Engineers Comments Regarding Surface Water Drainage

Application Reference:	A/30/26/PL	Reviewer Reference:	ADC/EXT5/AF
Planning Officer:	Kathryn Welch	Date of Review:	07/04/2026
Site Name:	Highdown Garden Centre Littlehampton Road Ferring BN12 6PG		
Application Description:	Demolition of existing open sided structures and erection of retail canopies and restaurant lobby. This application is in CIL Zone 3 (Zero Rated) as other development.		
Assessment Number:	1

Drawing No: A9803 - 140 P2

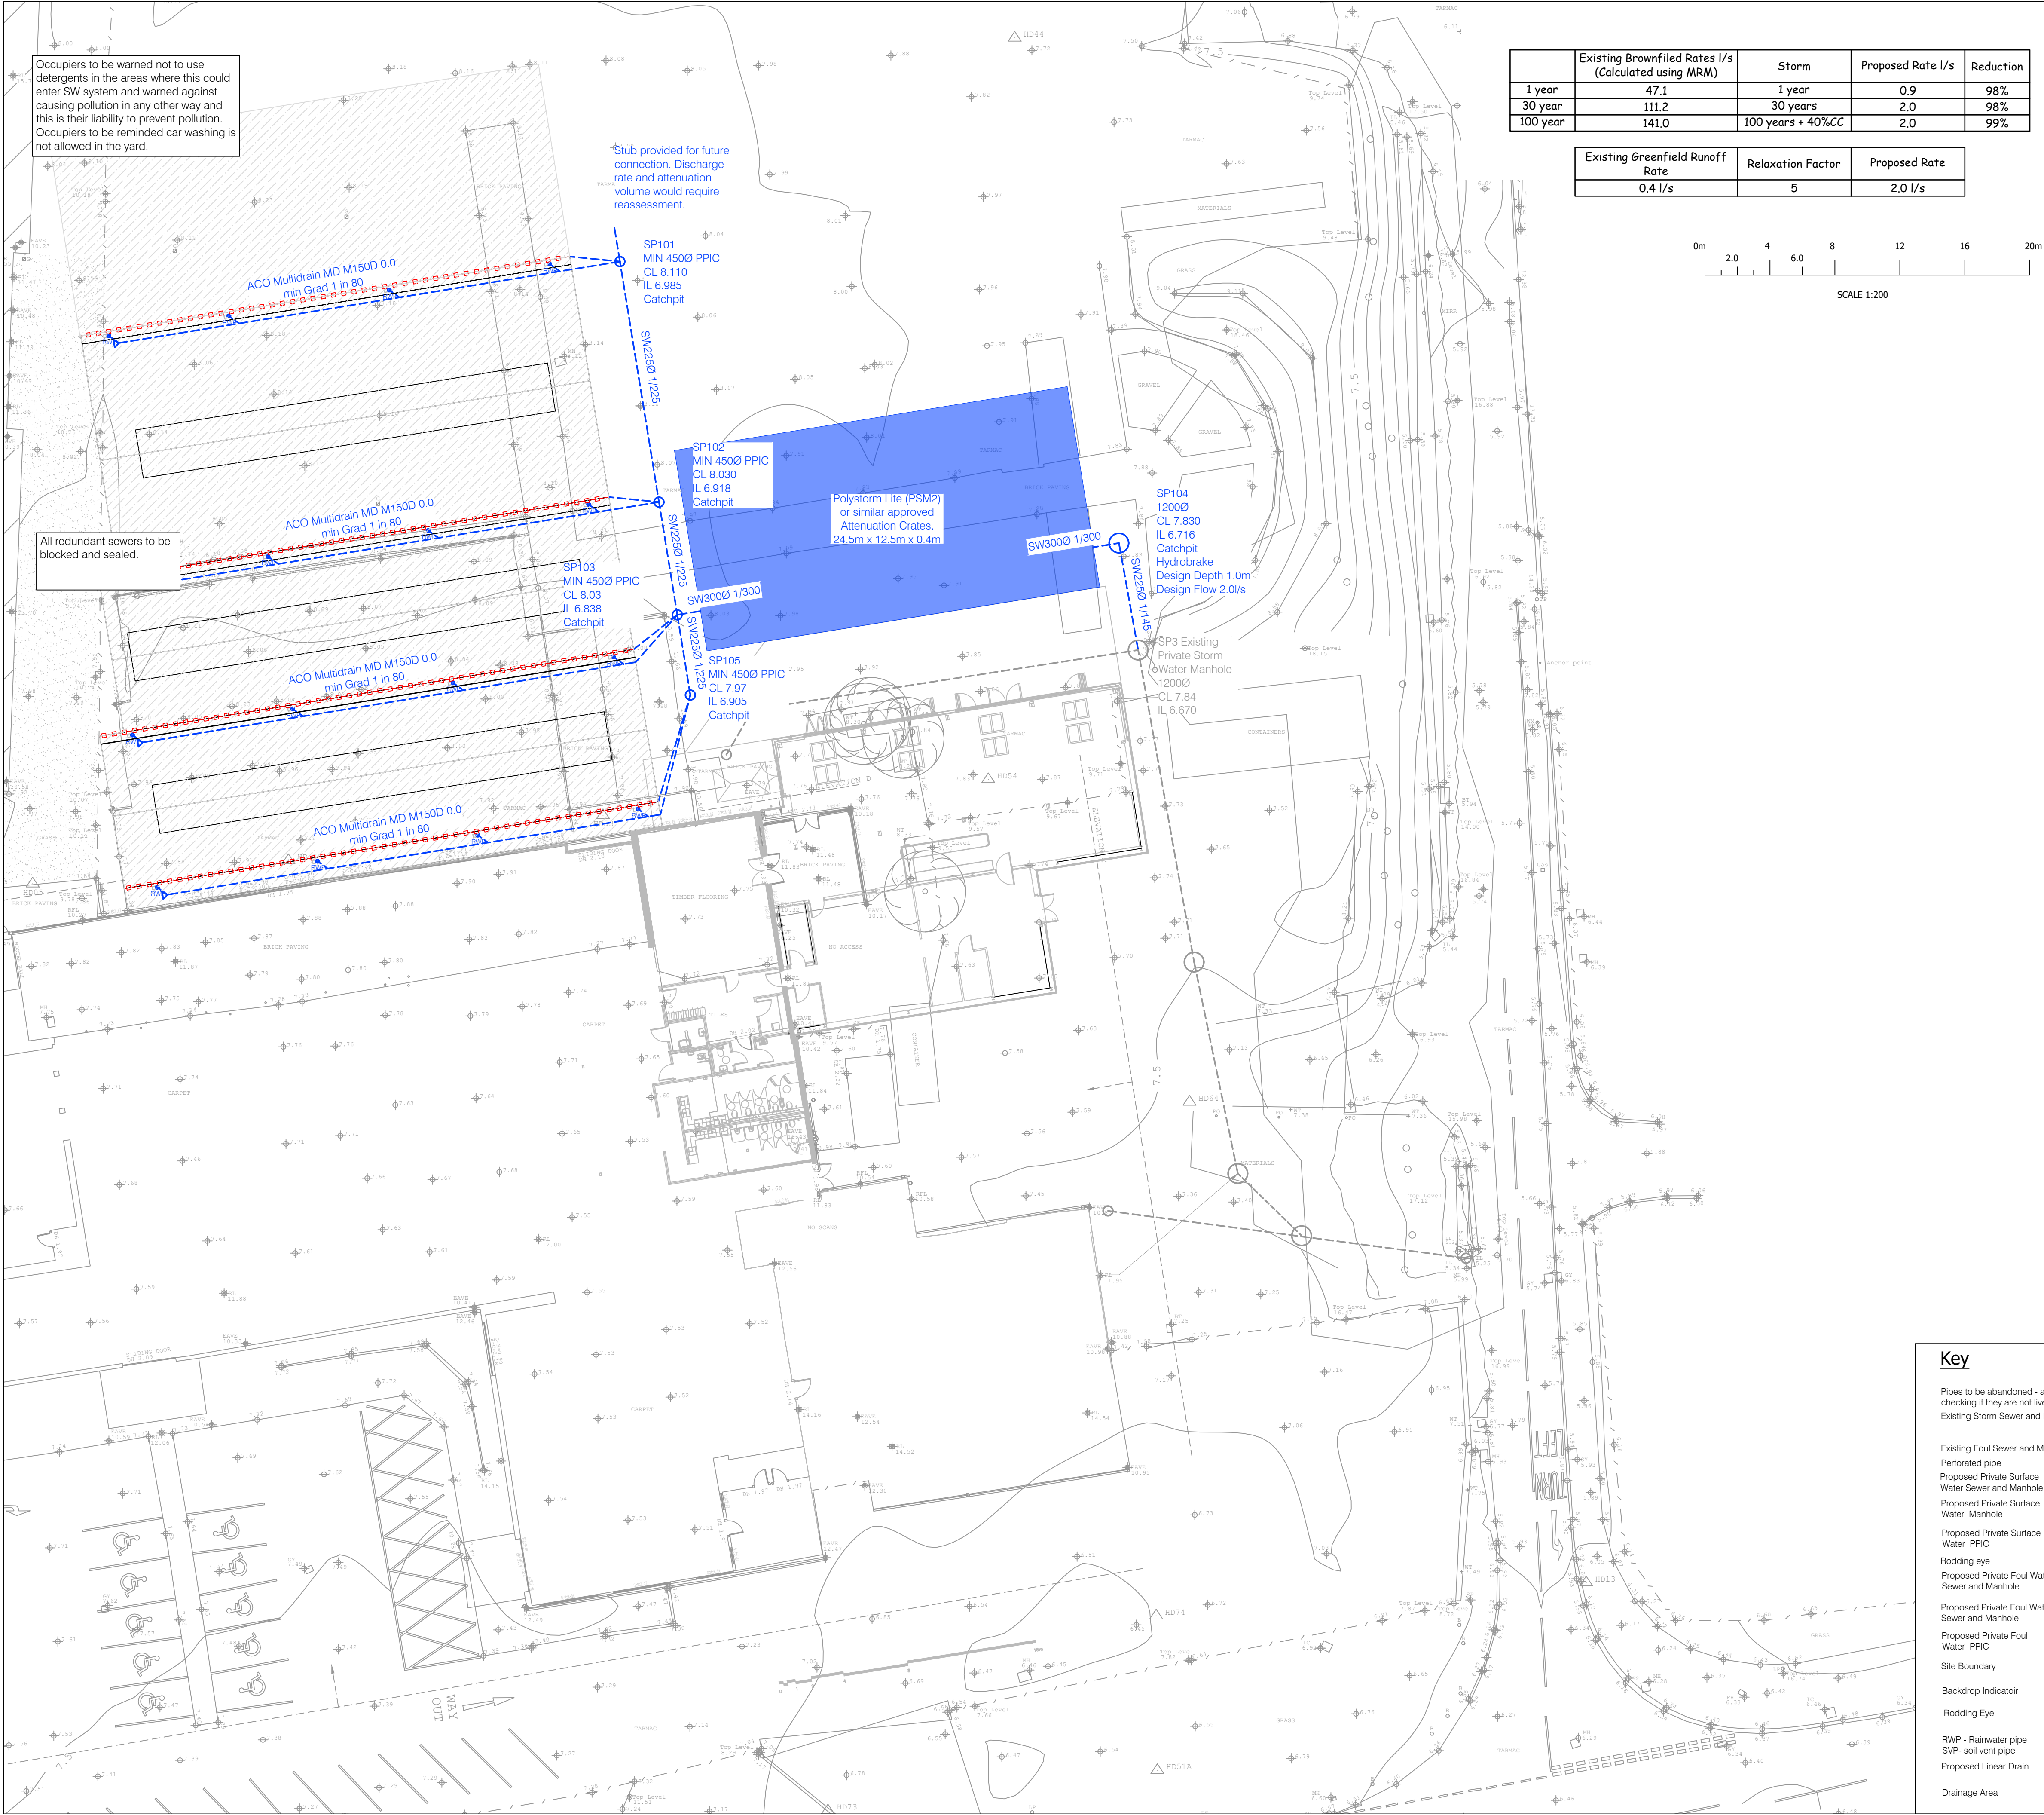
- 1.1. The proposed drainage layout shows a piped restricted outlet to the existing drainage system at the site. The downstream outfall is unclear but there is a piped ordinary watercourse shown on out records in the location.

- 3.1. The drainage layout shows flow restriction and below ground attenuation. The design peak flow rate should be assessed against greenfield runoff rates and calculations should be provided within a Drainage Statement.
- 3.2. Guidance is provided on ADC webpages - <https://www.arun.gov.uk/surfacewater>.
- 3.3. Management of extreme rainfall is not currently in accordance with the requirements of the NSfS Standard 3. Therefore, we **object** to the application.
